From: Simon Davis
Sent: 11 January 2022 16:33
To: Planning Scanning
Subject: FW: Planning Consultation on: AL/141/21/RES

Engineers Comments Regarding Surface Water Drainage

We have the following comments on the information submitted to support this reserved matters application. These points should be resolved prior to determination of this application to evidence that there is sufficient room for surface water drainage within the proposed layout.

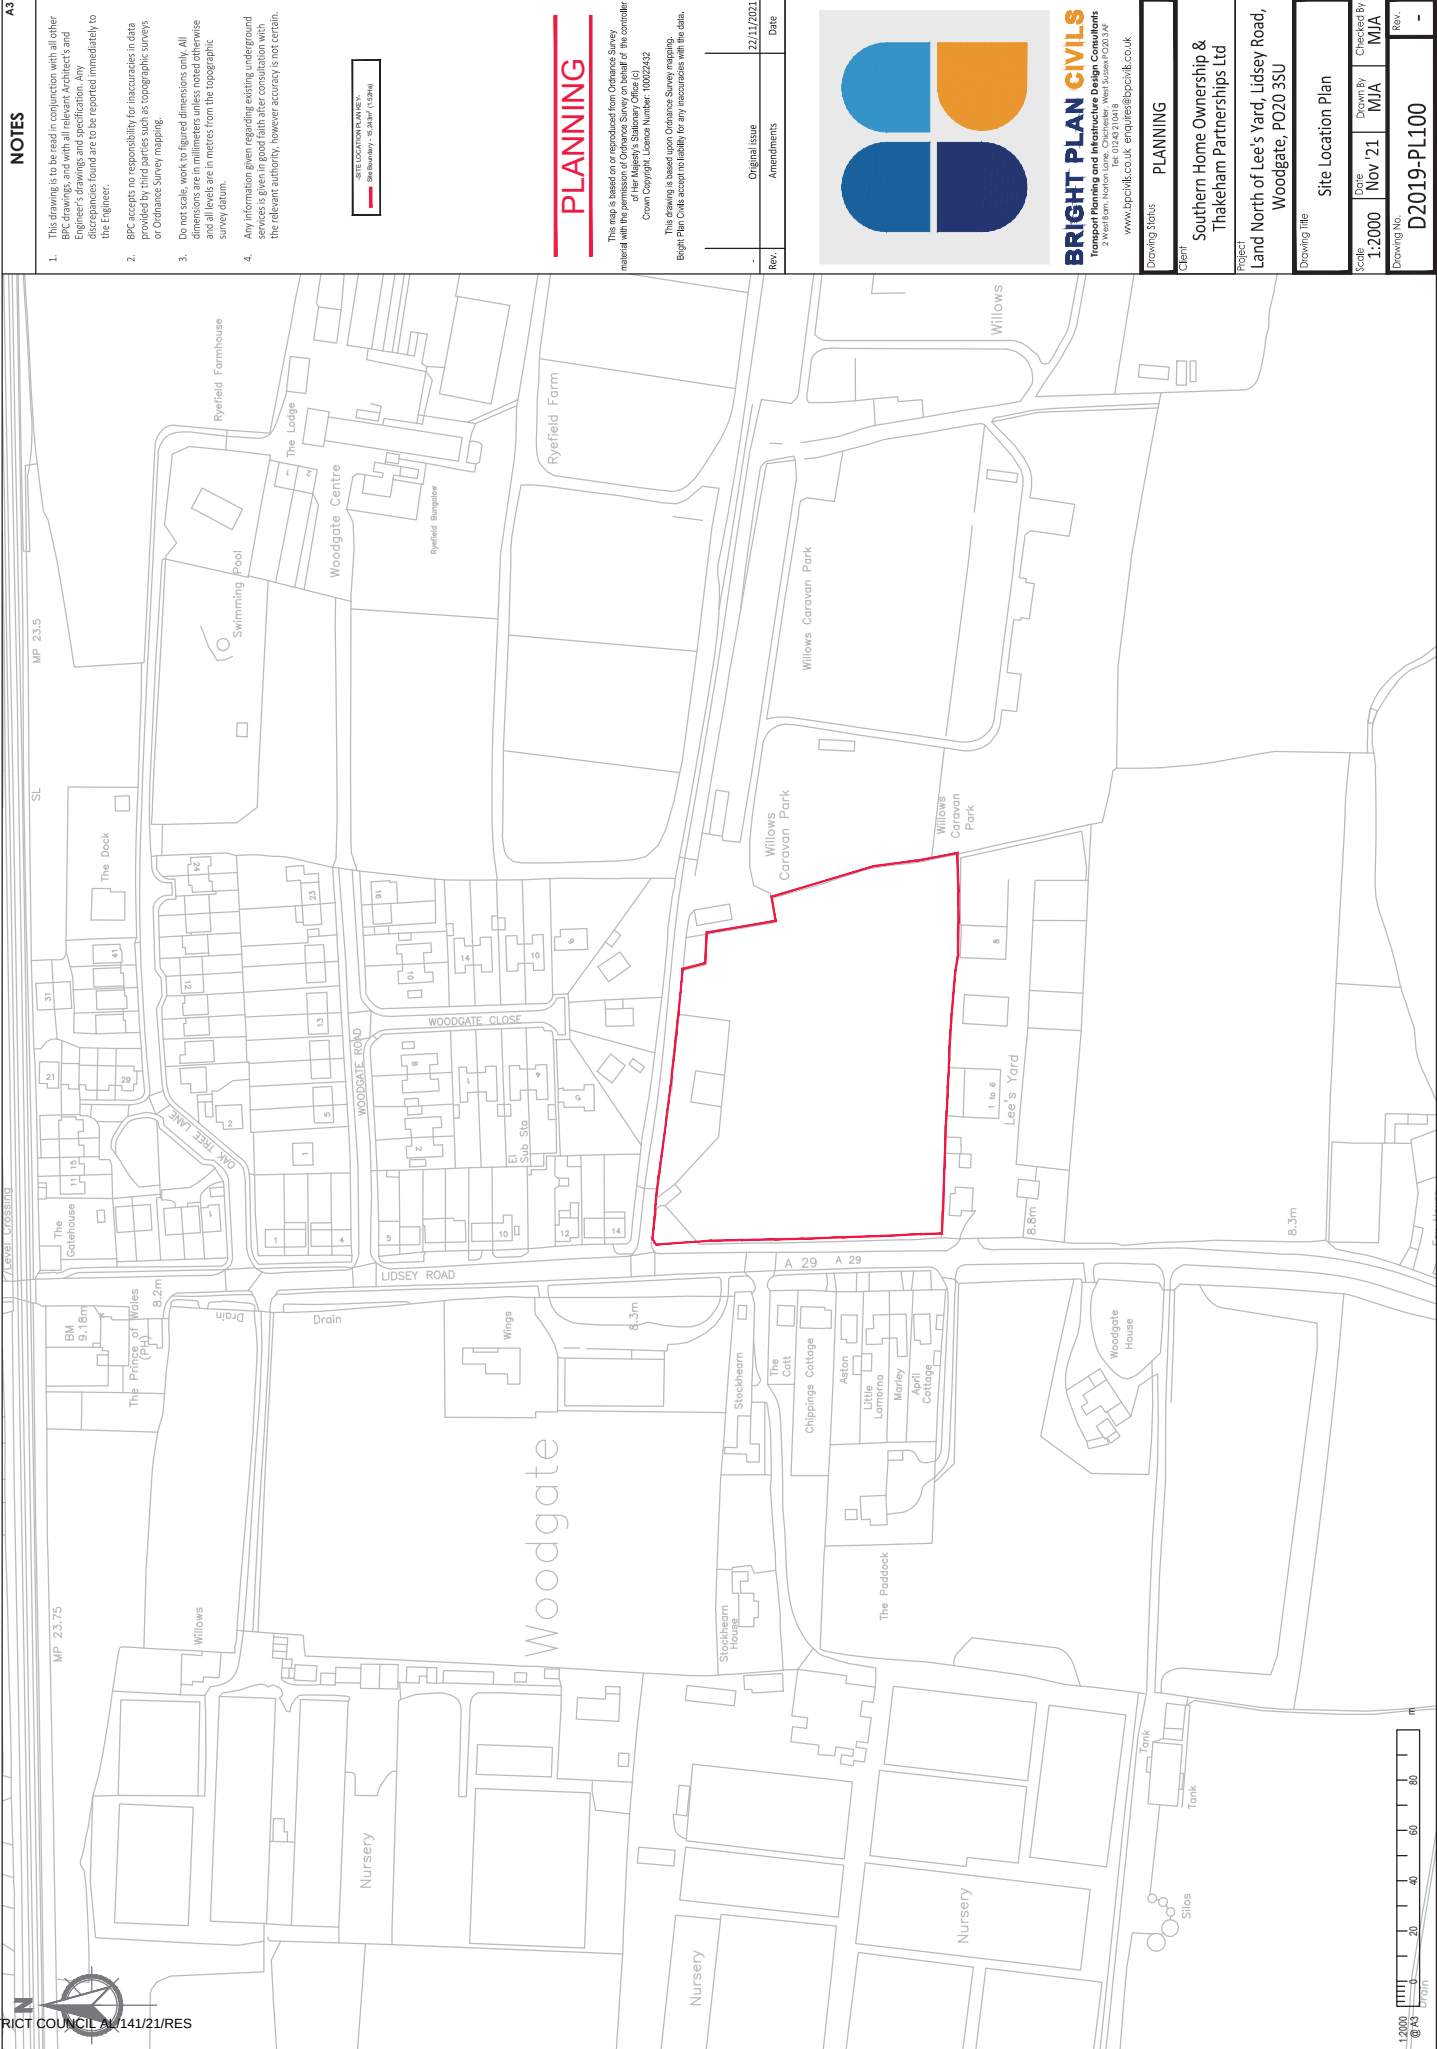
The proposed attenuation basin is proposed within very close proximity of the watercourse. The basin must be located a minimum of 3m from ordinary watercourse. The location of existing trees should also be carefully

considered with basin design. The basin is proposed to be bunded above surrounding ground level, this will result in water being held above surrounding ground level. Water should be retained below existing ground level as much as possible to remove the risk of breach.

1. Please adjust the basin position to ensure a minimum of 3m between the top of bank of watercourse and toe of retaining bund.
2. Please adjust the basin position to ensure a minimum of 3m between the toe of bund of the detention basin and existing tree root areas.
3. Please adjust the basin size to ensure that 300mm of freeboard is provided above peak anticipated water level.
4. Please adjust the basin so that it is set lower in the ground.
5. Please supply details of the improvements that will be completed to the ordinary watercourse.
6. Flotation calculations should be supplied to evidence that it will be possible to deliver the basin as proposed and that design will adequately consider the risk of floatation.
